CITY OF ALBUQUERQUE

Re: Quaker Heights Townhomes
99999 Quaker Heights Pl. NW
Traffic Circulation Layout
Engineer's Stamp 02-16-23 (F11-D020A)

Based upon the information provided in your submittal received 03-03-23, the above referenced plan cannot be approved for Building Permit until the following comments are addressed:

TCL

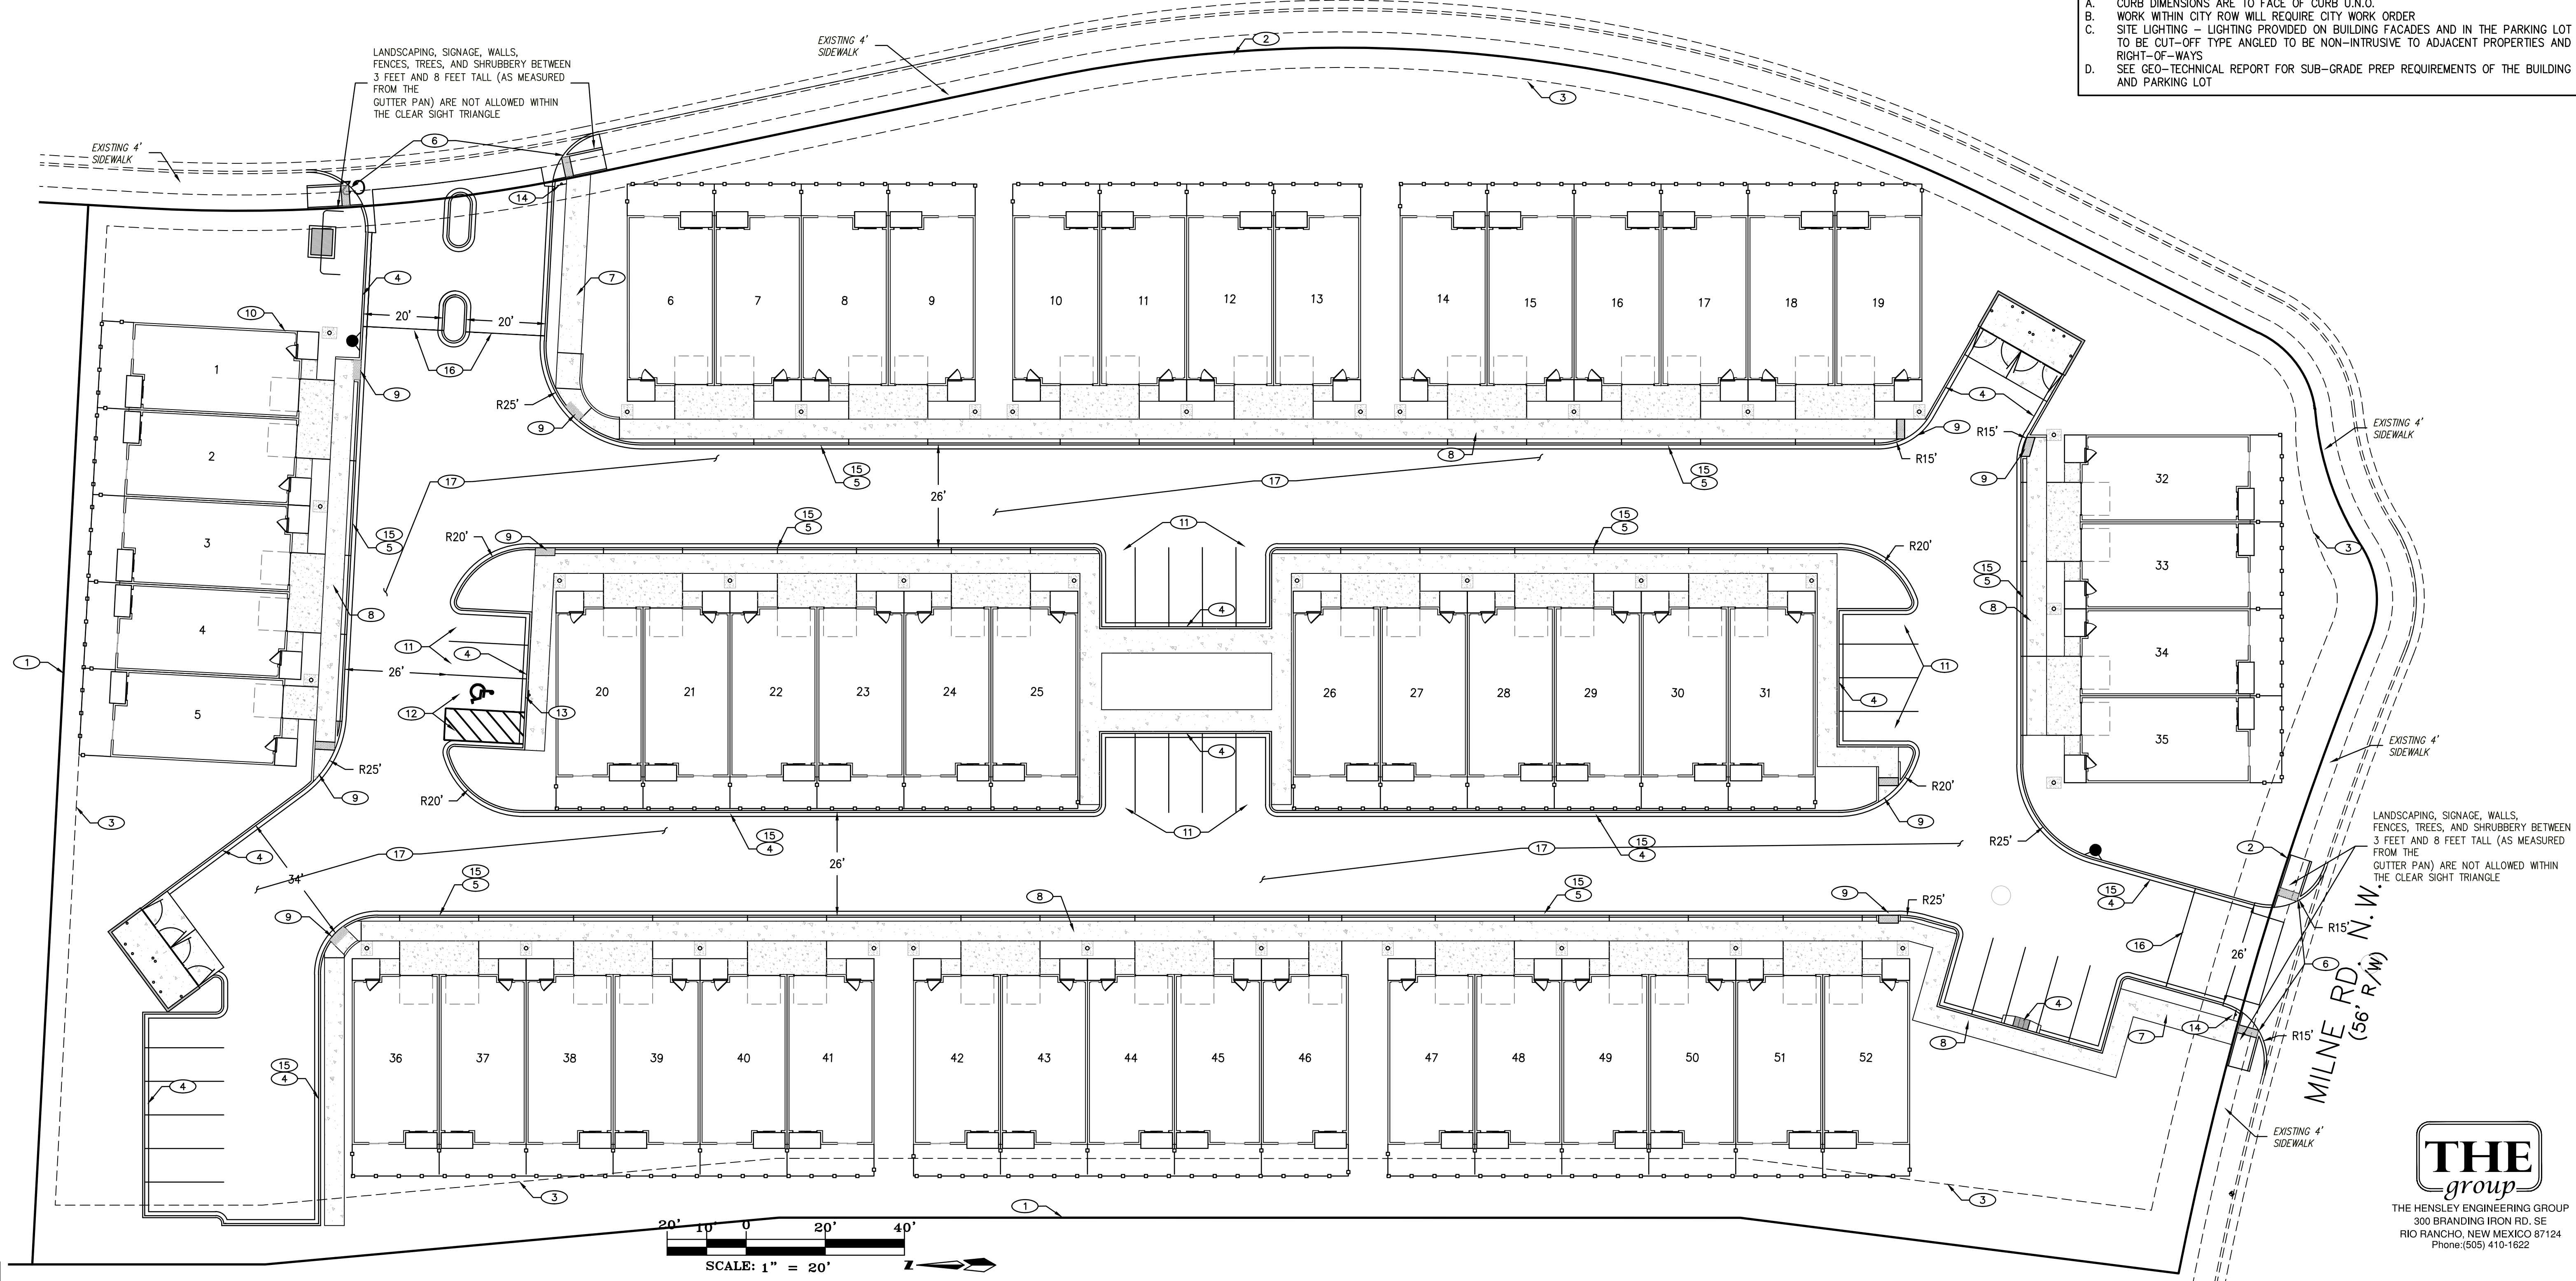
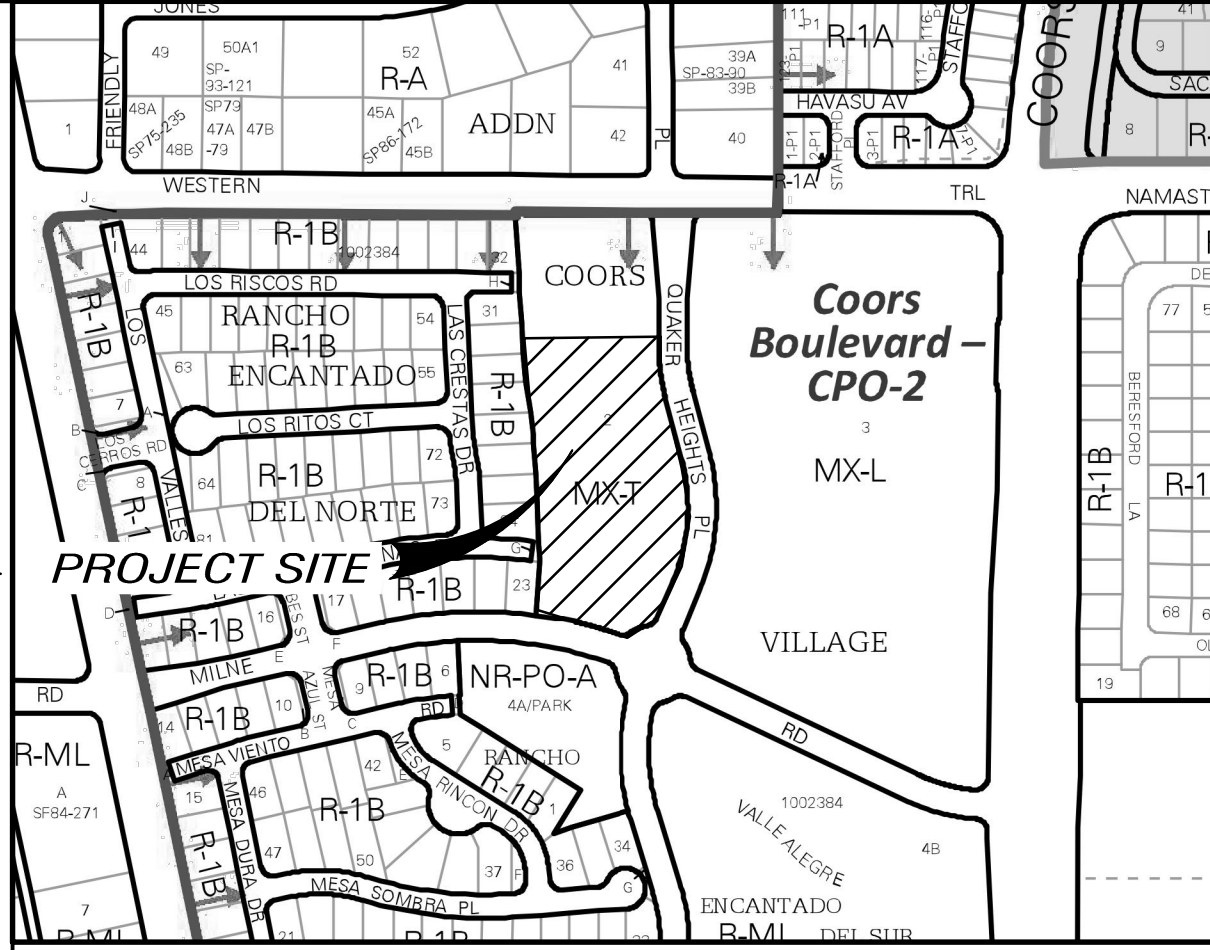
1. Identify all existing access easements and rights of way width dimensions.
2. Per new city requirements a minimum 5' wide public sidewalk must be built from property line to property line along Quaker Heights Pl. and Milne Rd.
3. Please check with Code Enforcement if Motorcycle and Bicycle parking spaces are required.
4. Provide ADA parking space dimensions.
5. Please define the ADA pathway from the ADA parking aisle to the building entrance by labeling of flush or ramps.
6. ADA curb ramps must be updated to current standards and have truncated domes installed.
7. A 5 ft. keyway is required for dead-end parking aisles at the north west side of the site.

8. Refuse vehicle maneuvering shall be contained on-site. The refuse vehicle shall not back into the public right of way.; provide a copy of refuse approval.
9. Provide a copy of Fire Marshal approval.

10. It is not apparent what type of pavement surface is being proposed. A hard driving surface will be required as part of this proposed project for parking area and drive aisles.

11. Please remove Refuse Enclosure details from Transportation details sheet.
12. Please specify the City Standard Drawing Number when applicable.
13. Please add a note on the plan stating "All improvements located in the Right of Way must be included on the work order."
